Technical Note

Project No: ITB14377
Project Title: Land South of Green Lane, Chesterton
Title: Oxfordshire County Council Response
Ref: TW/GT/SPH/ITB14337-009a
Date: 22 March 2023

- 1.1 An outline planning application was submitted by Wates Developments to Cherwell District Council (CDC) in January 2023, (ref: 23/00173/OUT) for 147 dwellings on Land south of Green Lane, Chesterton.

DRAWN:	JD	CHECKED:	IN	APPROVED:	TW
PROJECT No:	ITB14377	SCALE @ A3:	1:1000 / 1:500	DATE:	19.08.20
DRAWING No:	ITB14377-GA-001	REV:	F

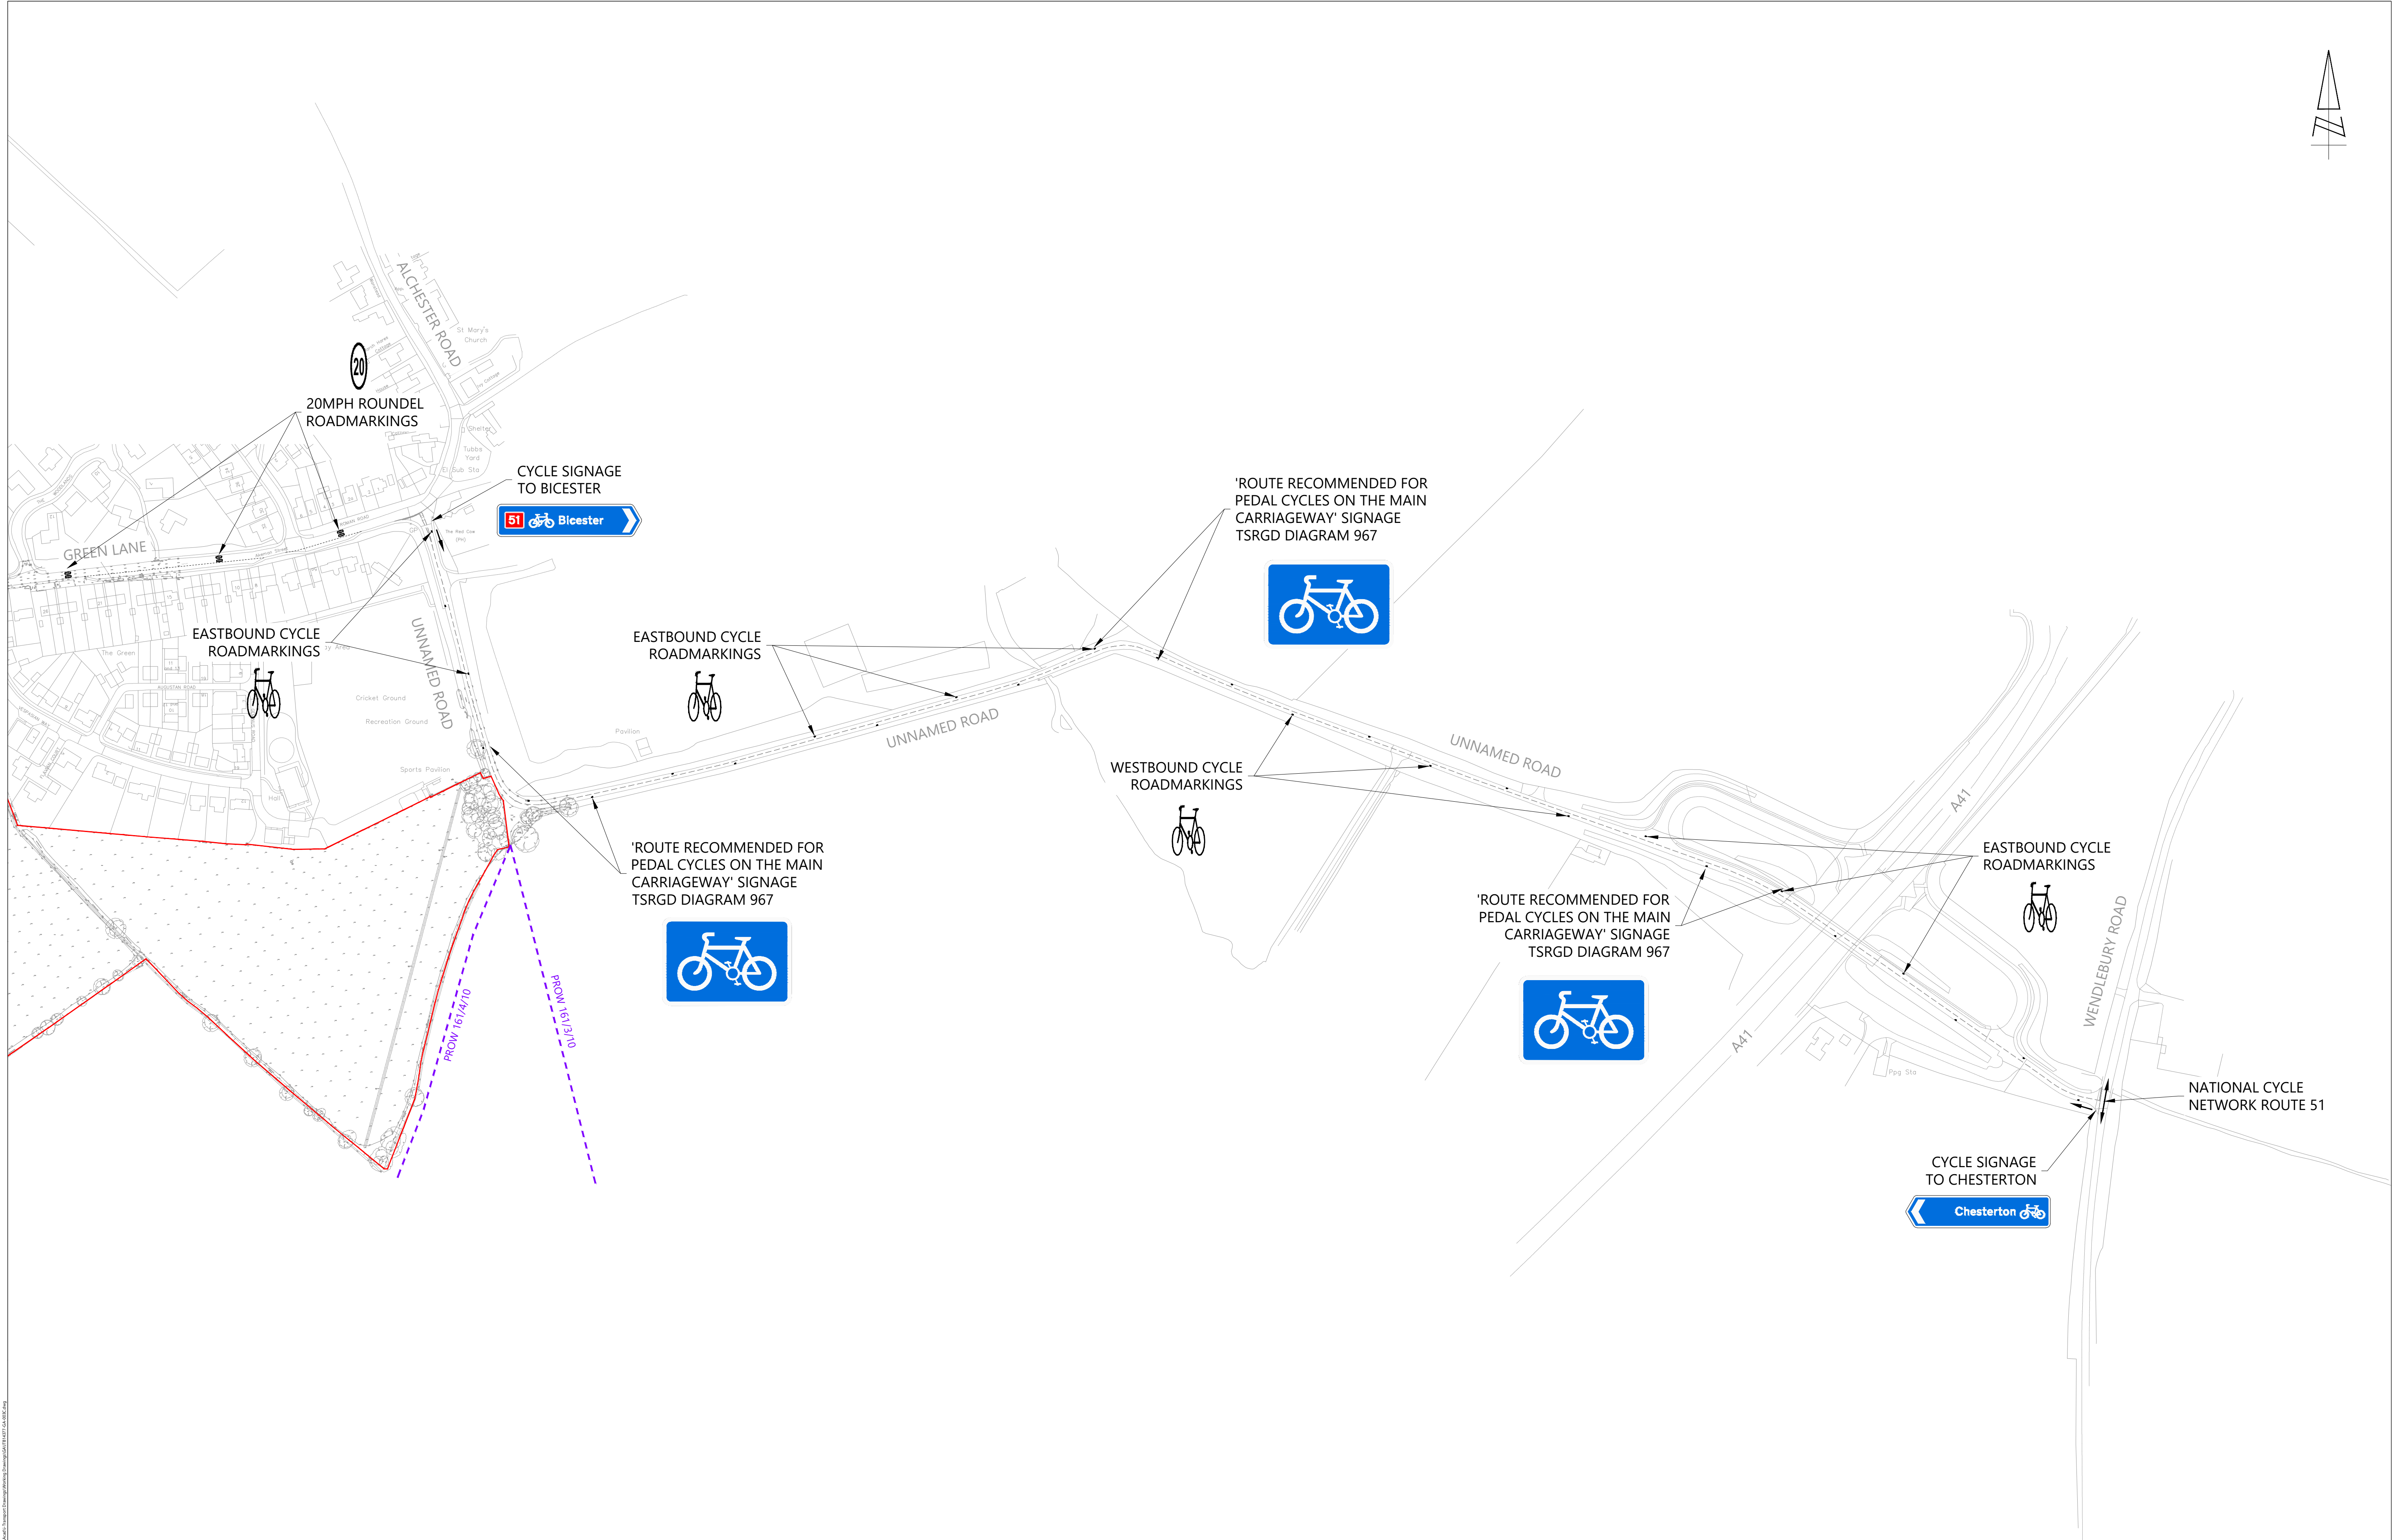
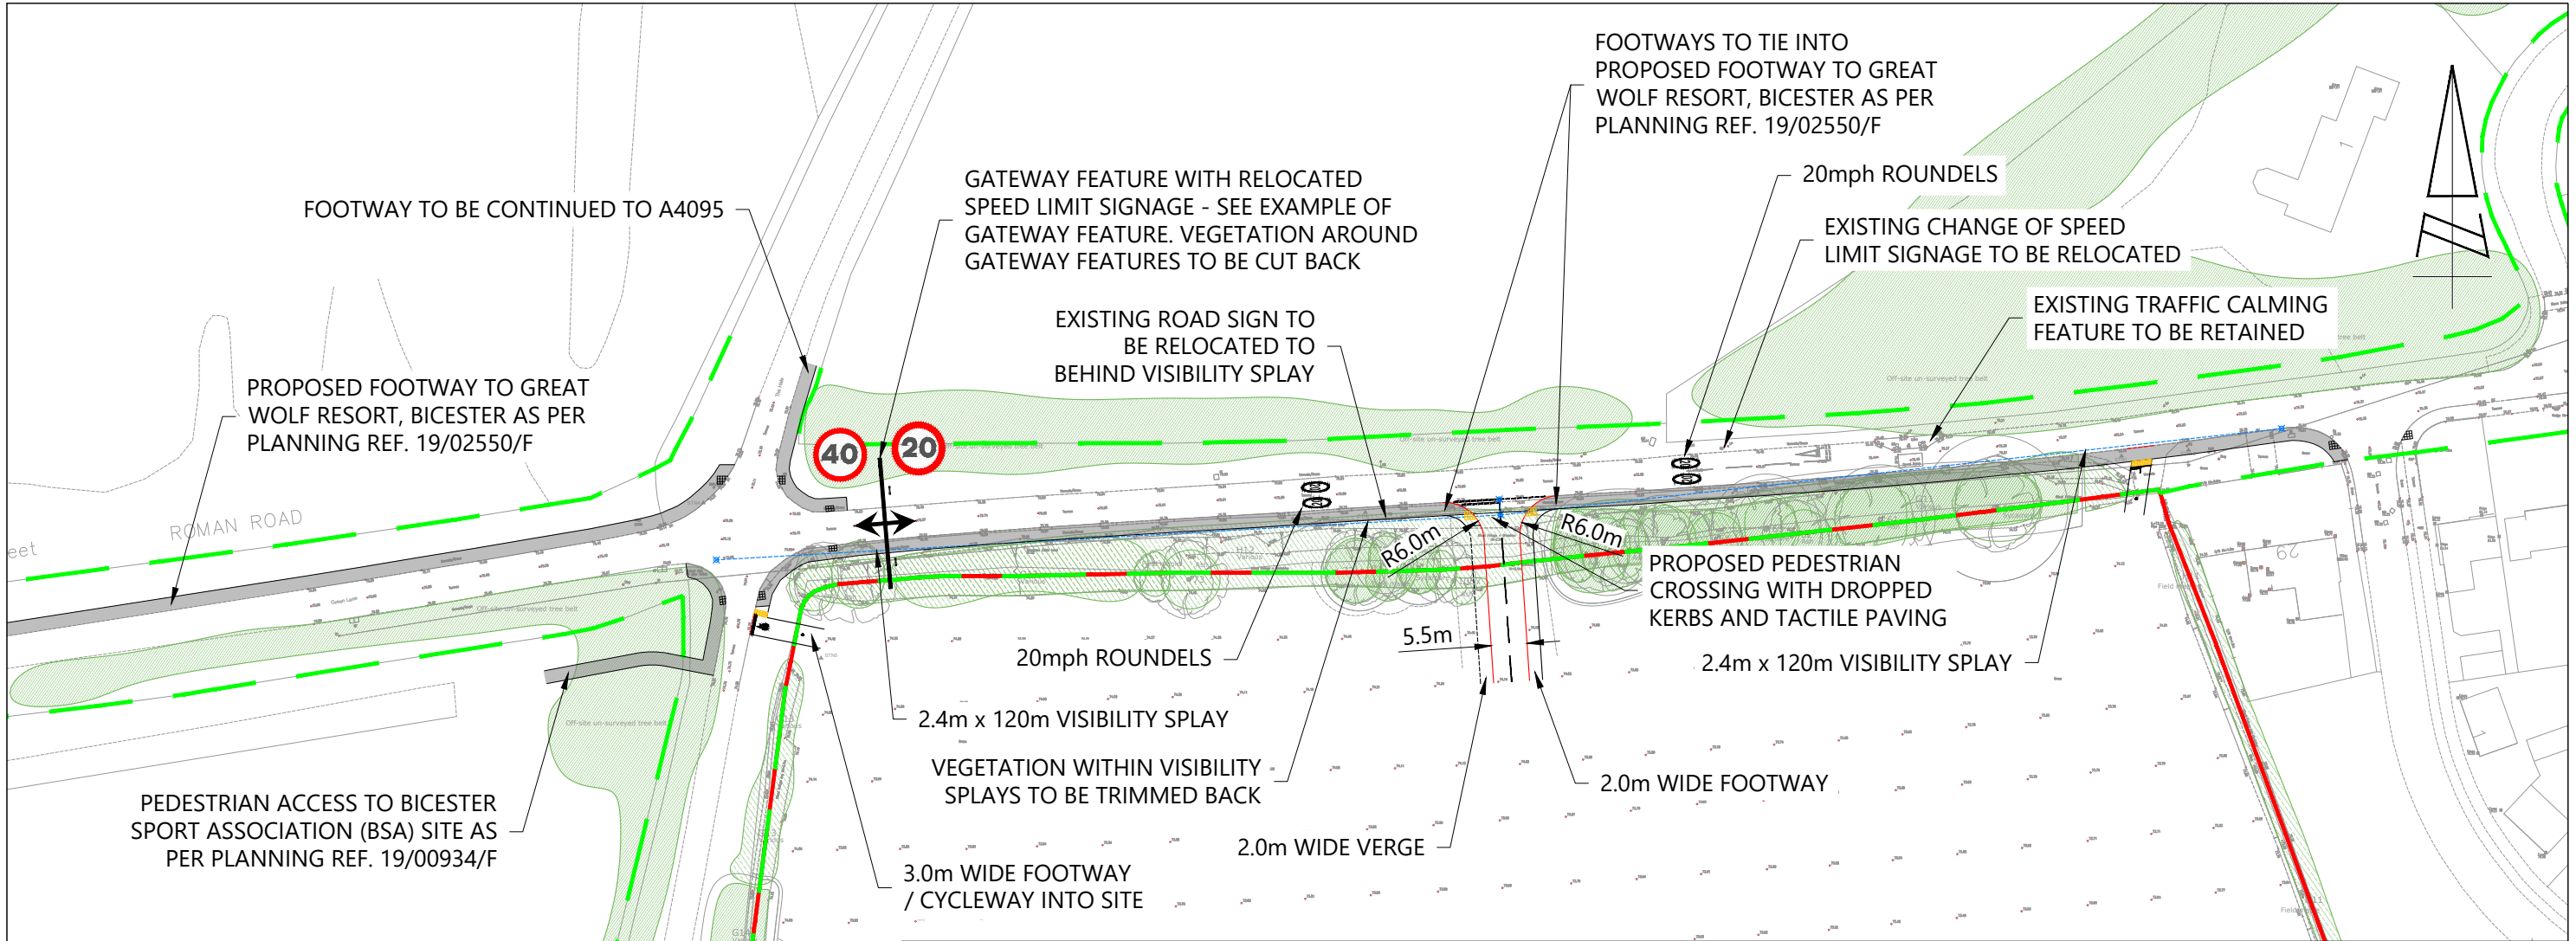
- Paragraph 3.7.7 notes that "*There is a small cluster of accidents at the junction of Green Lane / The Hale and whilst assessment does not identify a significant trend in the causation factors of the accidents and these are relatively low in number, there would be merit in an improvement scheme being considered in this location to refresh road markings, improve signage and enhance the visibility and reading of the junction. The applicant would be willing to provide a contribution towards a safety improvement scheme at this location.*" The size of this contribution is not specified but can be identified and included in the Section 106 agreement for this development.

- Section 4.3 presents site access arrangements. These are considered acceptable and can be the subject of a Section 278 agreement. However, a long section has not been provided and this is considered necessary. Further details are given below under the **Road Agreements** heading.

3.6 Nevertheless, the junction is included within the scope of the proposed access junction works, which itself proposes various improvements to Green Lane and its junction to The Hale, including delivering footway connections, relocating speed limits and signage (Image 3.4 – Drawing ITB14377-GA-001 Rev F). Any further signage and markings necessary would be best addressed as part of the approval of the Section 278 works to Green Lane.

- The highway safety scheme at Green Lane / The Hale identified in the TA has recently been delivered by OCC and is no longer necessary. Nevertheless, the Site access works include the junction and can include any necessary signage / markings at the S278 stage;

- The Road Agreement comments have been reviewed and addressed where appropriate. The long section of the site access road has also been prepared for OCC review and demonstrates the works can be delivered in line with prevailing standards; and
